**Parramatta Powerhouse  
Response to Further Submissions – Mod 1 to State Significant Development Consent SSD-10416**

We write on behalf of Infrastructure NSW (the Proponent) in relation to the Section 4.55(1A) Modification Application (MOD 1) to the Powerhouse Parramatta project (SSD-10416) at 34-54 and 30B Phillip Street and 338 Church Street, Parramatta (the site). This letter sets out the Proponent's response to further submission provided by the City of Parramatta Council in response to the Submissions and Amendment Report. A detailed response to Council's letter is provided at **Attachment A**.

1 PROPOSED ELEVATION S  
1 : 100

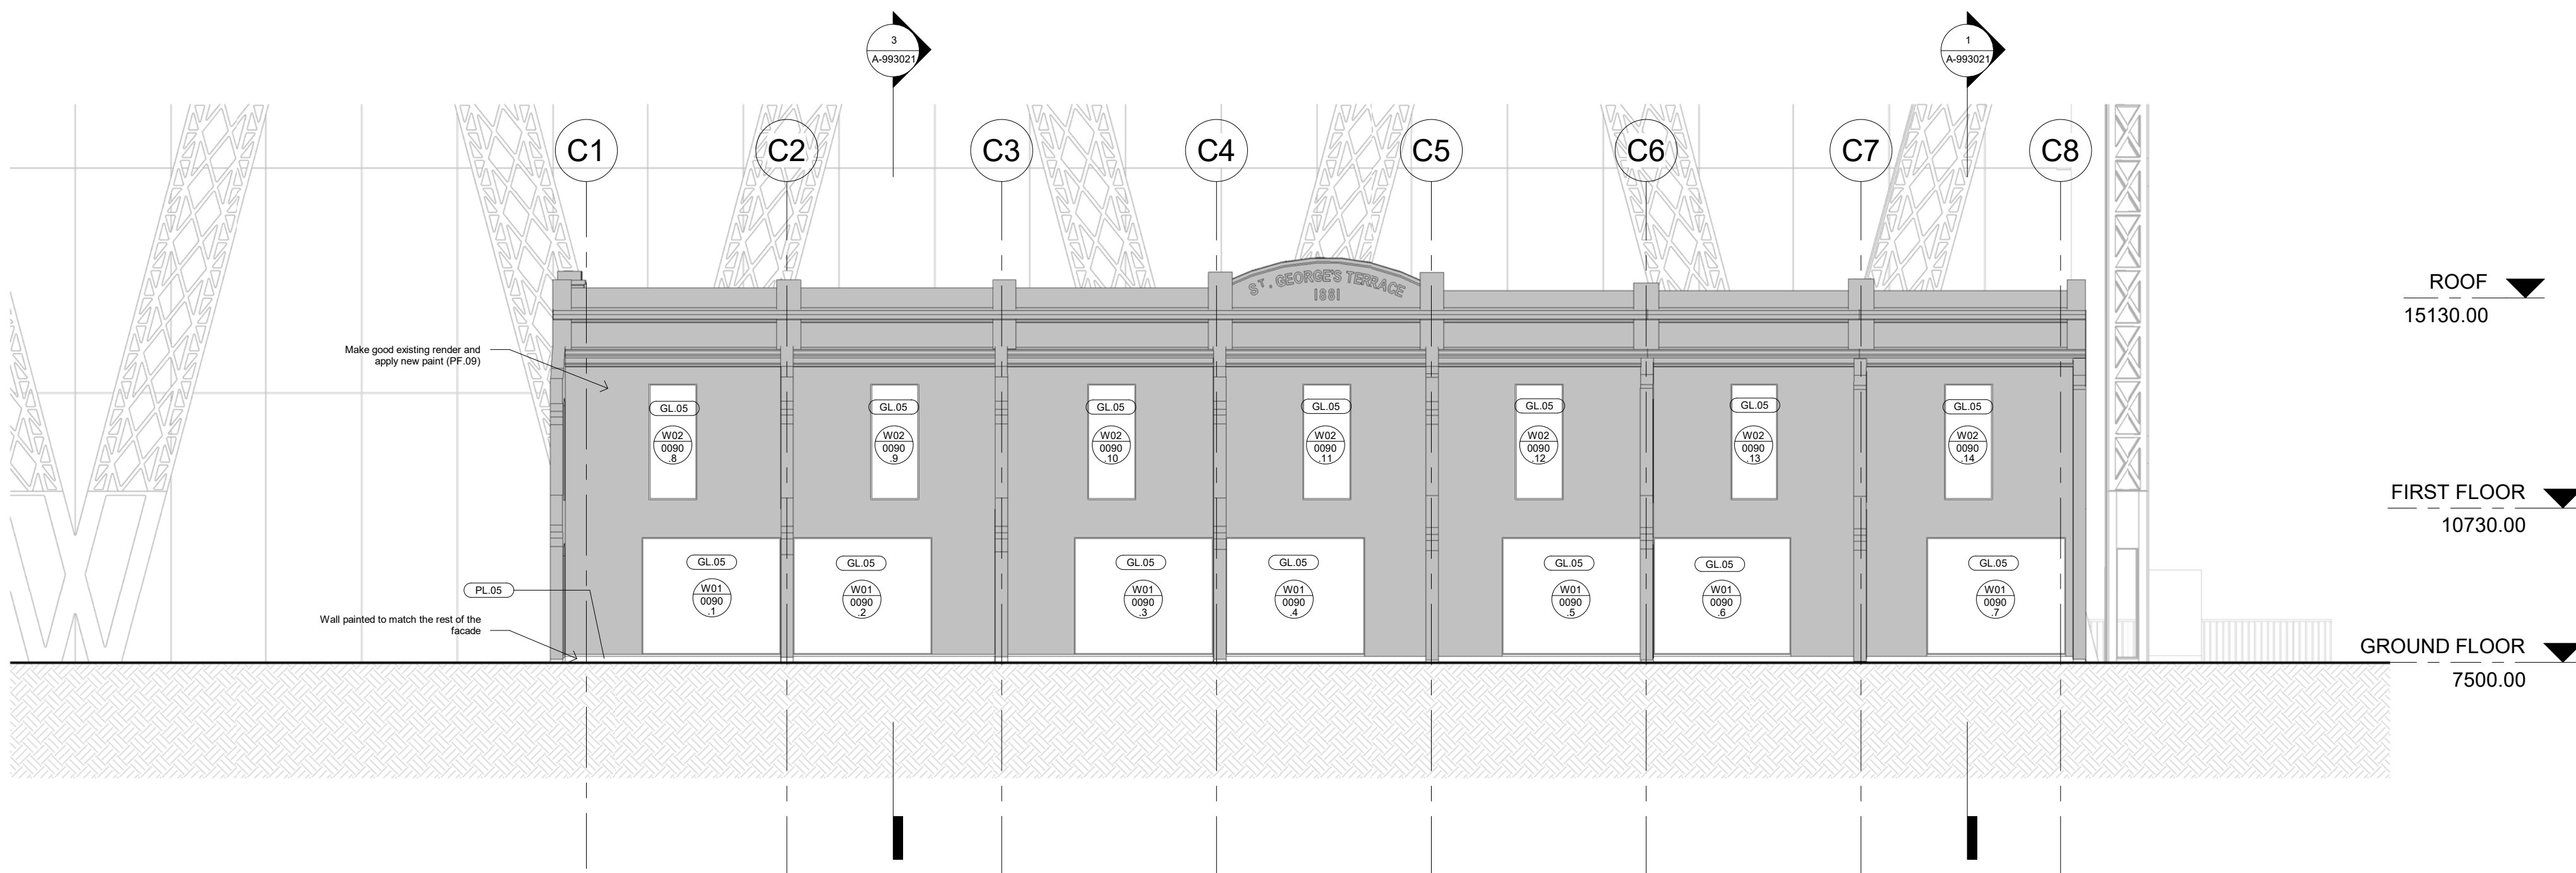
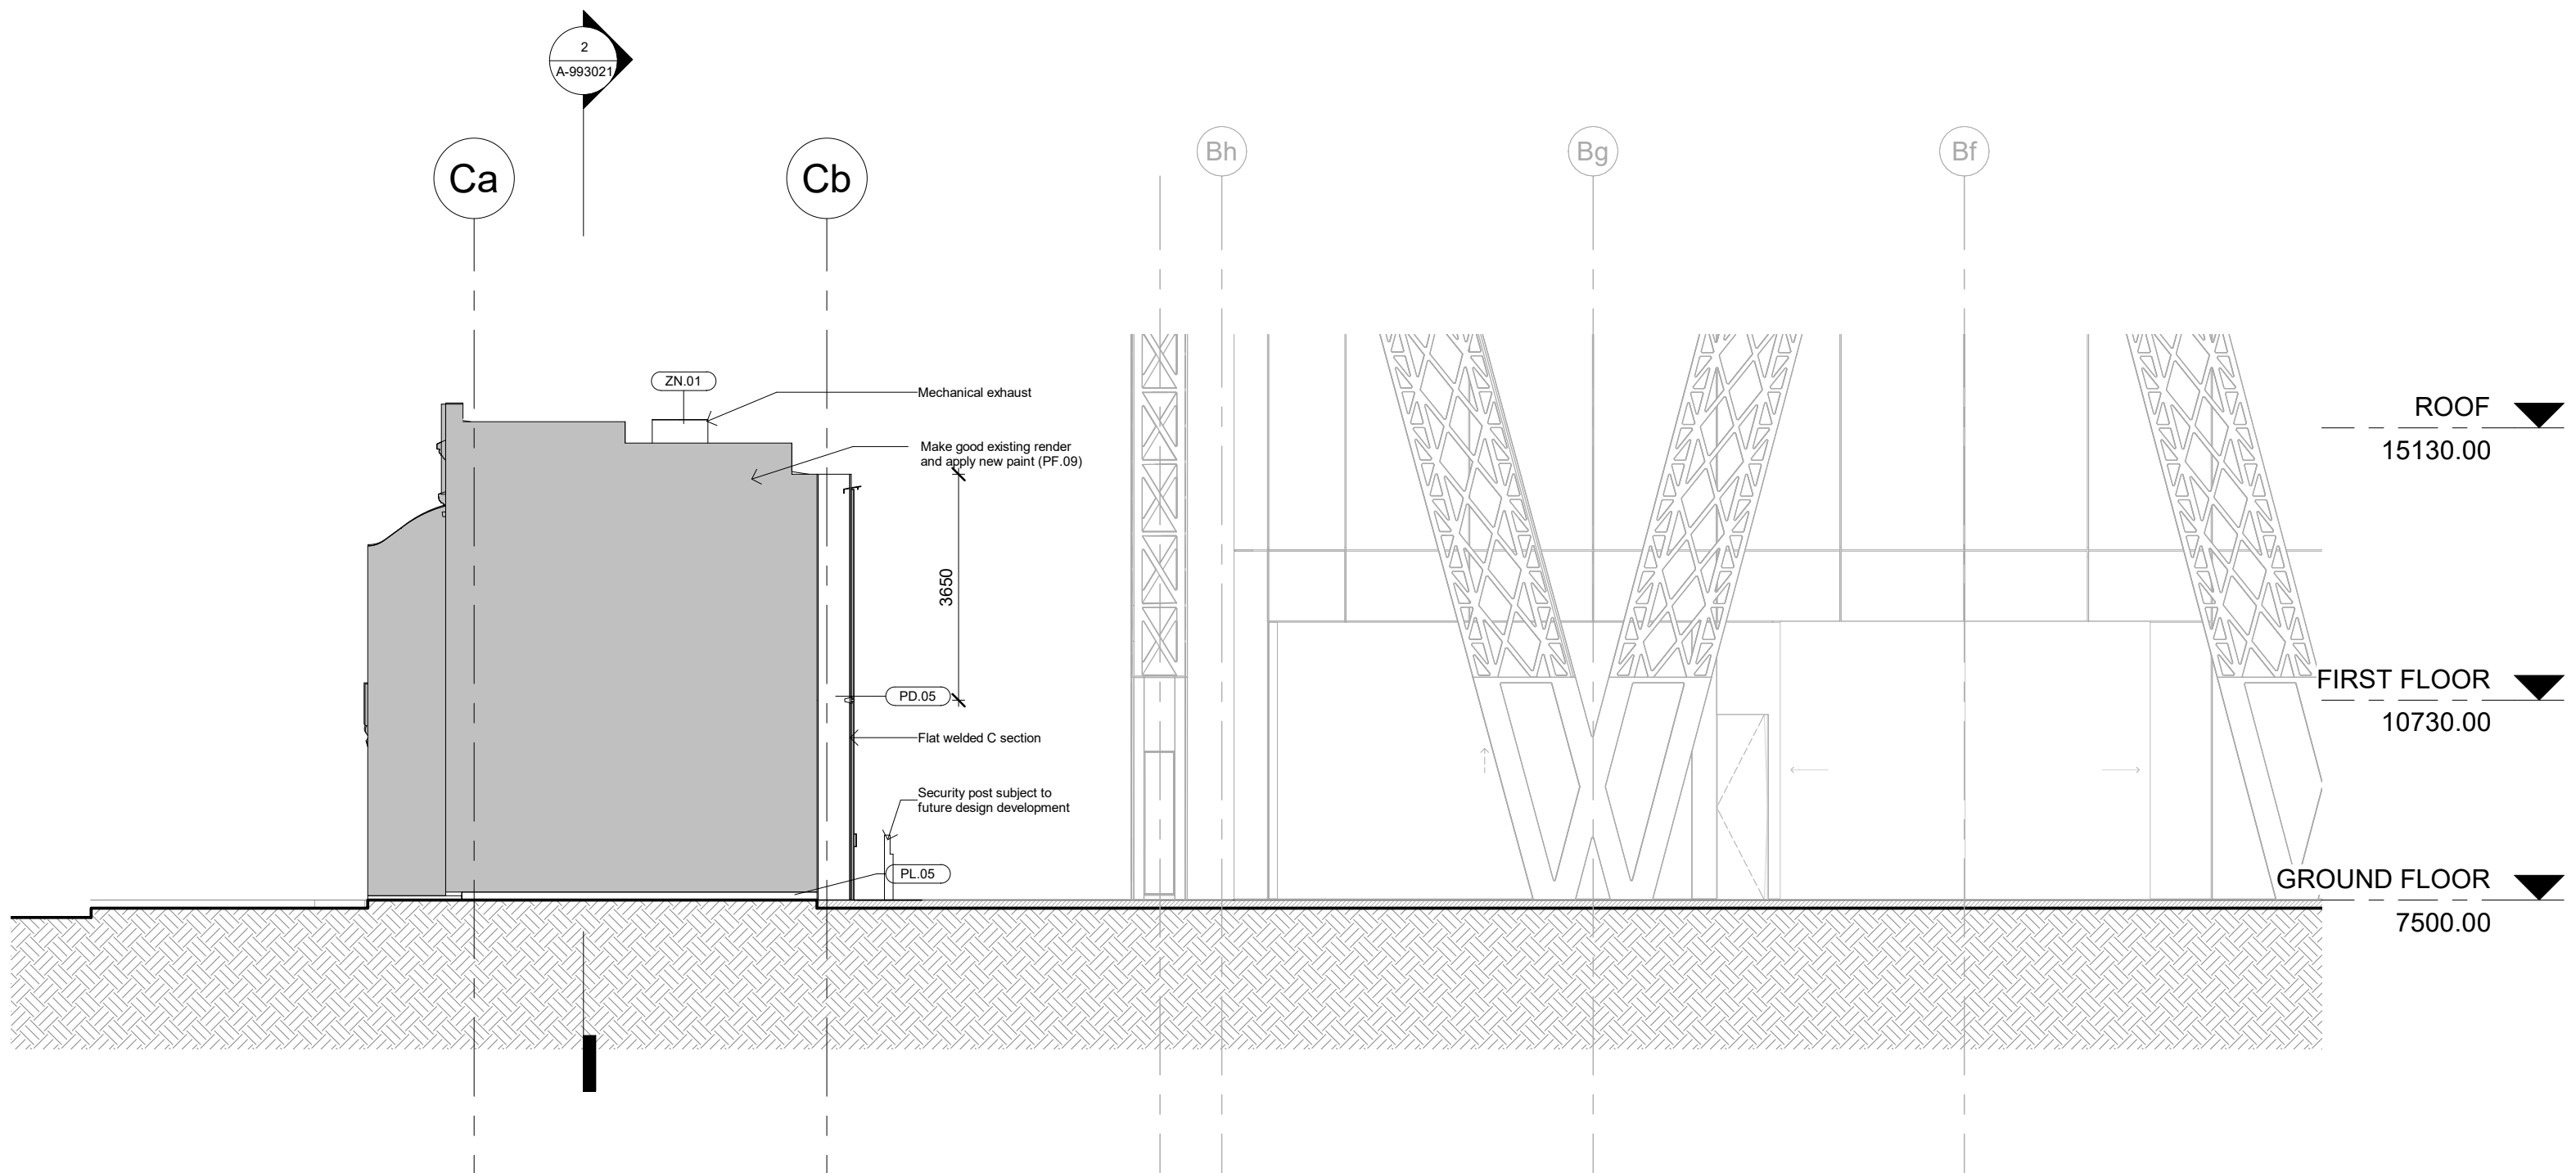
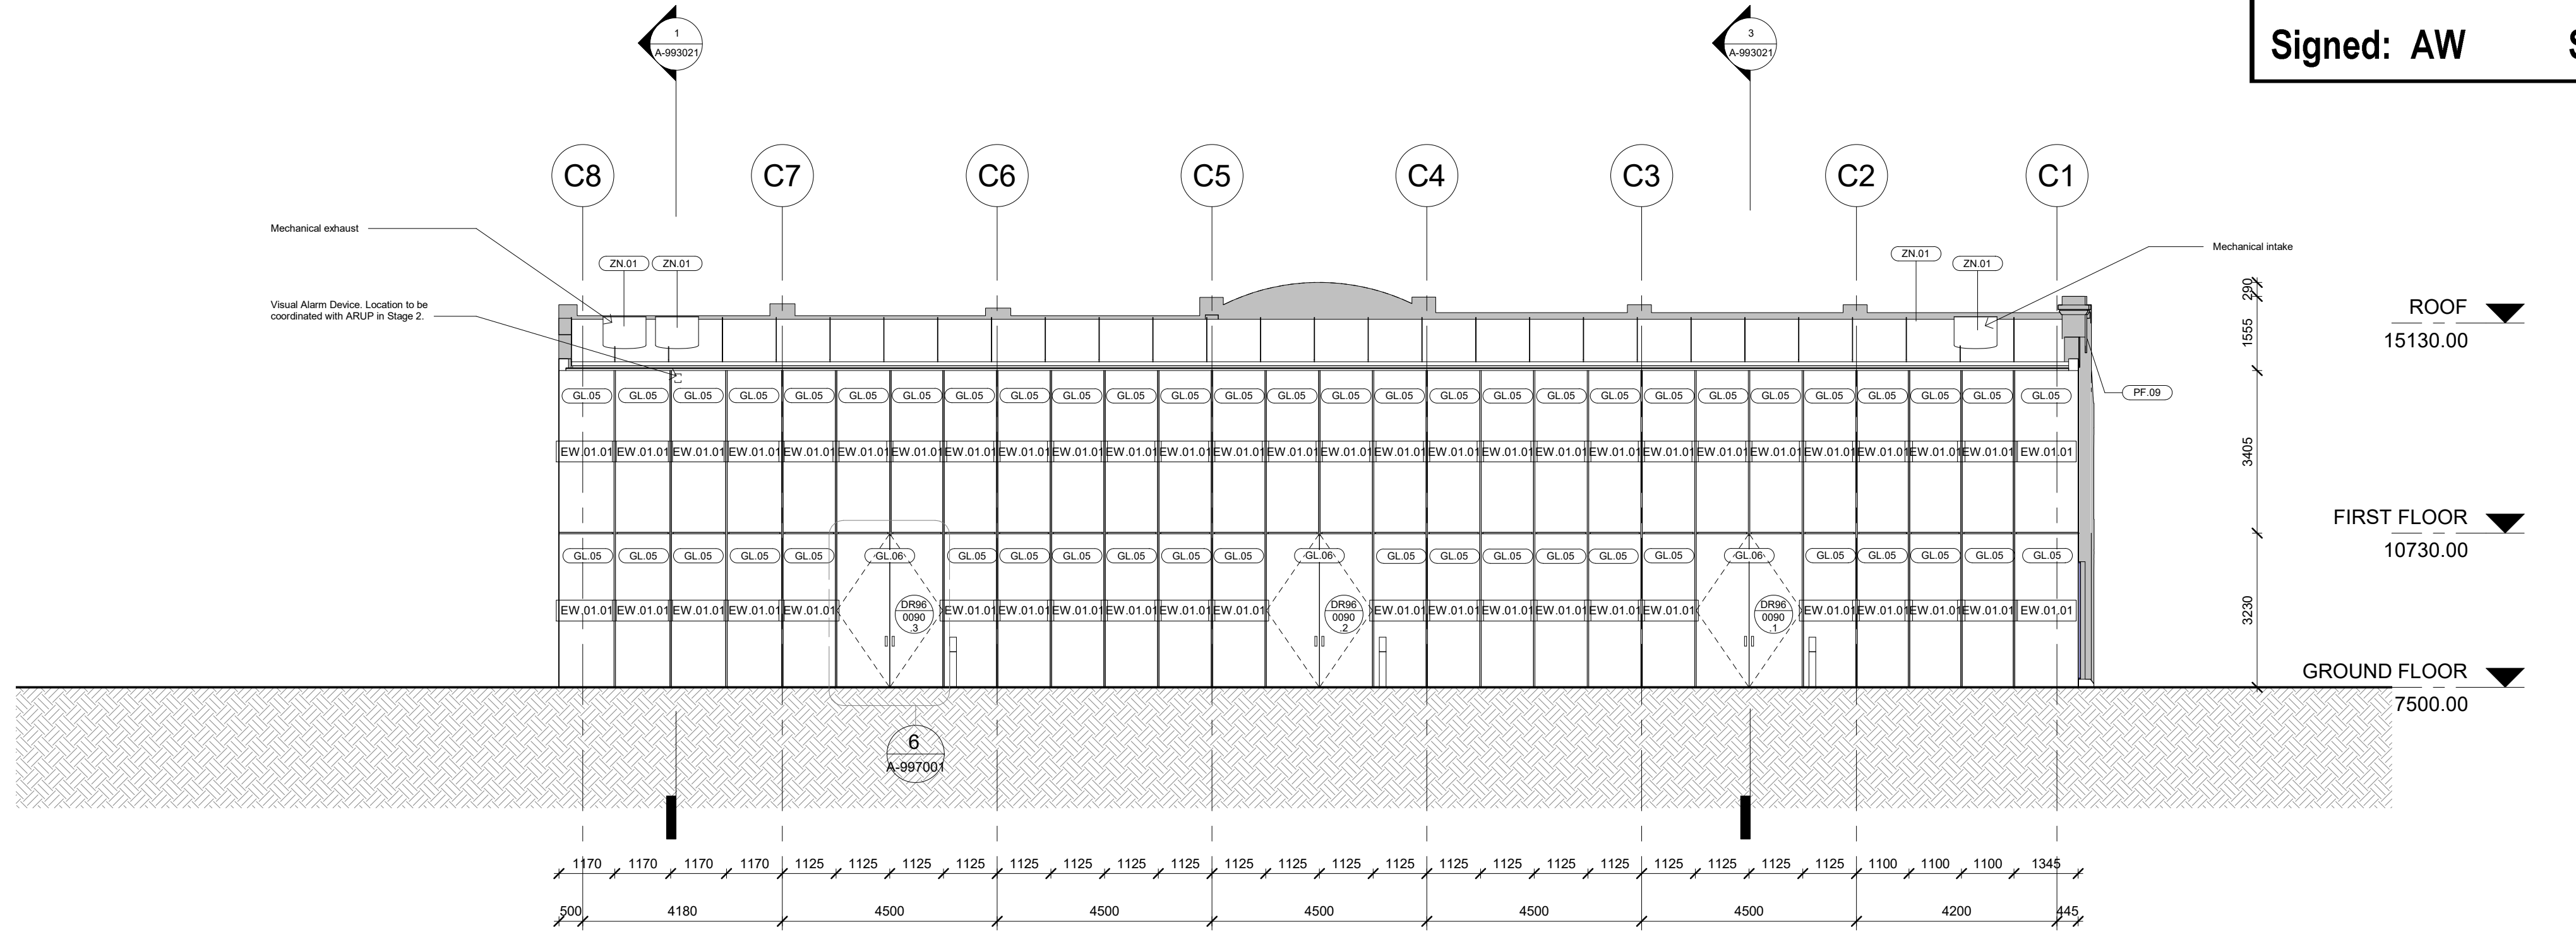
COPC16	2. The window and door openings should be reinstated to the original proportions, including the removal of the brick window infills.	The Applicant has considered Council's comment and will commit to reinstating the original proportion of openings with window/door arrangements that would represent the original fabric whilst maintaining current building standards and maintaining the design integrity of Powerhouse Parramatta.
COPC17	3. Fill or reconstruct the additional opening spaces at ground level that were created to convert each terrace into a commercial business with shop front incorporating door (between 1970 and 1978). This should be based on historical evidence if any and the use of sympathetic materials compatible with the building's heritage value is recommended.	<p>As outlined, the proposed internal layout is considered to best serve an adaptive reuse of the terrace for Powerhouse Parramatta. The poor existing condition of the terrace reflects its unsuitability for ongoing use as smaller individual spaces. As such the internal walls will be removed.</p> <p>The Applicant commits to reinstating the Phillip Street façade openings to represent that of the original fabric.</p>

COPC27	The applicant is concerned that Council has requested changes to the doors and windows that would appear as an imitation. This is not the case, Council requests a design inspired by the Victorian proportions that would allow an appropriate interpretation of the original façade prior to the unsympathetic 1970s changes. The new elements requested are not supposed to appear as an imitation.	The Applicant has considered Council's comment and will commit to reinstating the original proportion of openings with window/door arrangements that would represent the original fabric whilst maintaining current building standards.
COPC28	The veranda reinstatement would make a significant contribution to the street view and overall heritage preservation. St George Terraces are a rare example of its typology of terraces within the Parramatta LGA and Parramatta CBD and should be restored to its maximum potential.	<p>The reinstatement of the first floor verandahs is not considered feasible or warranted. Access to the verandahs would not be possible with the proposed internal design that is required in order to ensure the functional adaptive reuse of the Terrace for the Powerhouse Parramatta.</p> <p>The Applicant has already committed to reinstatement of the plaster urns as part of the Response to Submissions.</p>
